**SEAGATE HOMES (UK) LIMITED
H16-0515-25 HORSESHOE ROAD, SPALDING
RESIDENTIAL DEVELOPMENT OF 76 DWELLINGS AND ASSOCIATED INFRASTRUCTURE**

Please find enclosed revised details for the above application, as detailed below. The new material has been prepared in response to comments made on the application through the consultation period.

S108 - 02 - Elevations 1:100 @A3 March 2025 MD

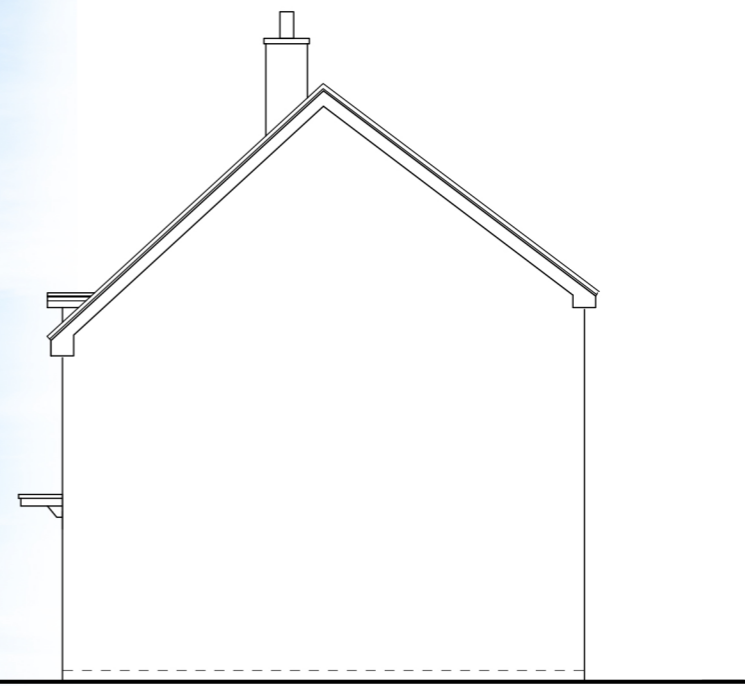
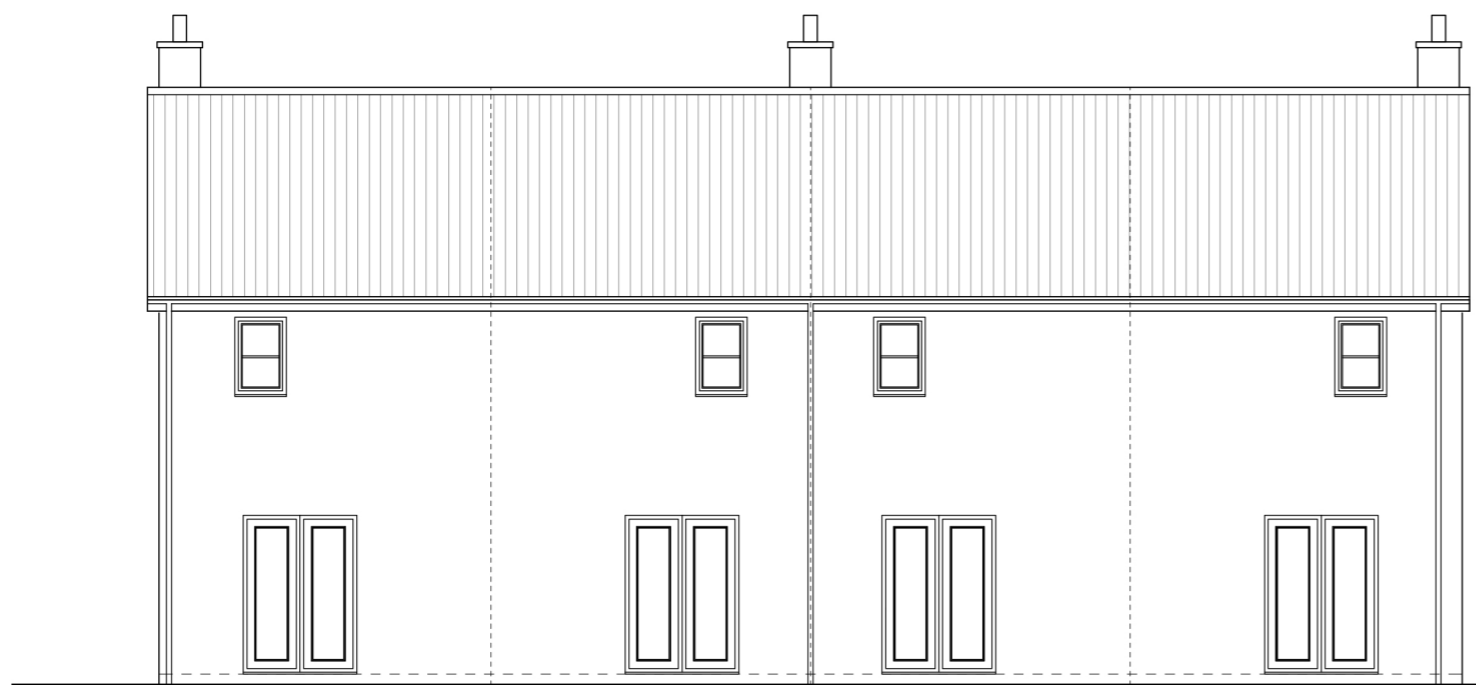
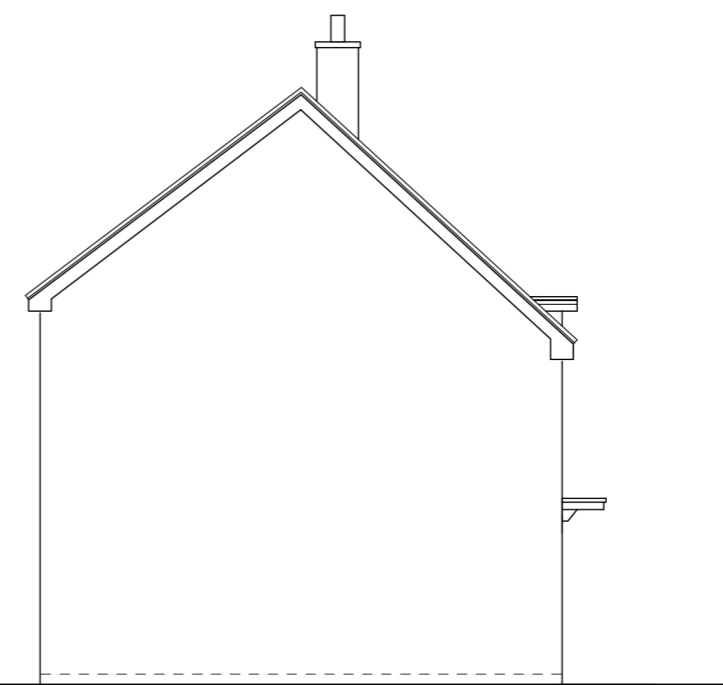
Plots 62-65 have been changed from maisonettes to terraced housing to overcome concerns about parking. Planting has been provided at both ends of the run of four parking spaces. The adopted approach will avoid moving the parking for one house’s parking in front of its neighbour.
